Harnett County Government Complex
307 W. Cornelius Harnett Boulevard
Lillington, NC 27546

Youth & Family Enrichment Connect
1503 Denim Drive
Erwin, NC 28334

The application and site plan for the proposed daycare, Youth & Family Enrichment Connect, located at 1503 Denim Dr. Erwin, has been reviewed and is disapproved at this time. Additional information is requested in order to complete the plan review for this facility. It is highly recommended you contact the NC Division of Child Development and start the licensing process. Please update our office with any changes per requirements from the Division of Child Development.

After School Care  
1503 Denim Drive, Erwin NC

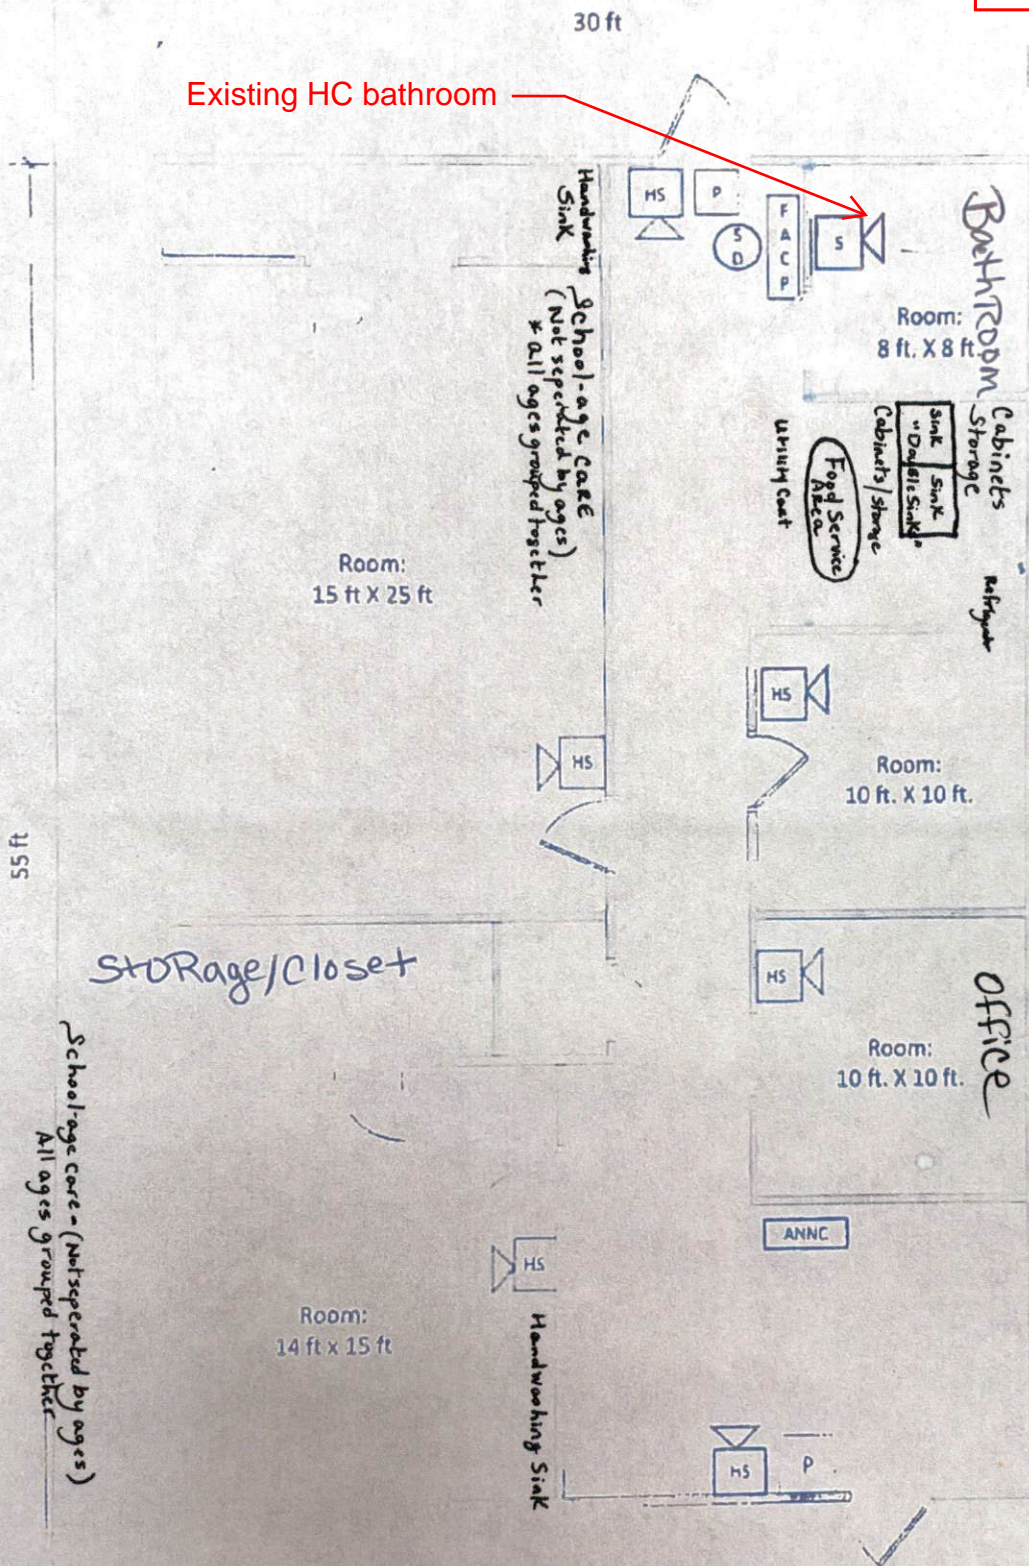
2. Provide a site plan to scale. Each child care classroom should have the age group that will be using that classroom. If this could change throughout the day, please indicate this on the site plan and include all age groups who may use this classroom.

3. Indicate the location of all handsinks and toilets.
4. Provide the name of the caterer you intend to use. Provide a menu of snacks and beverages you intend to serve the children. Provide information on storage of snacks and beverages and how and where they are prepared.
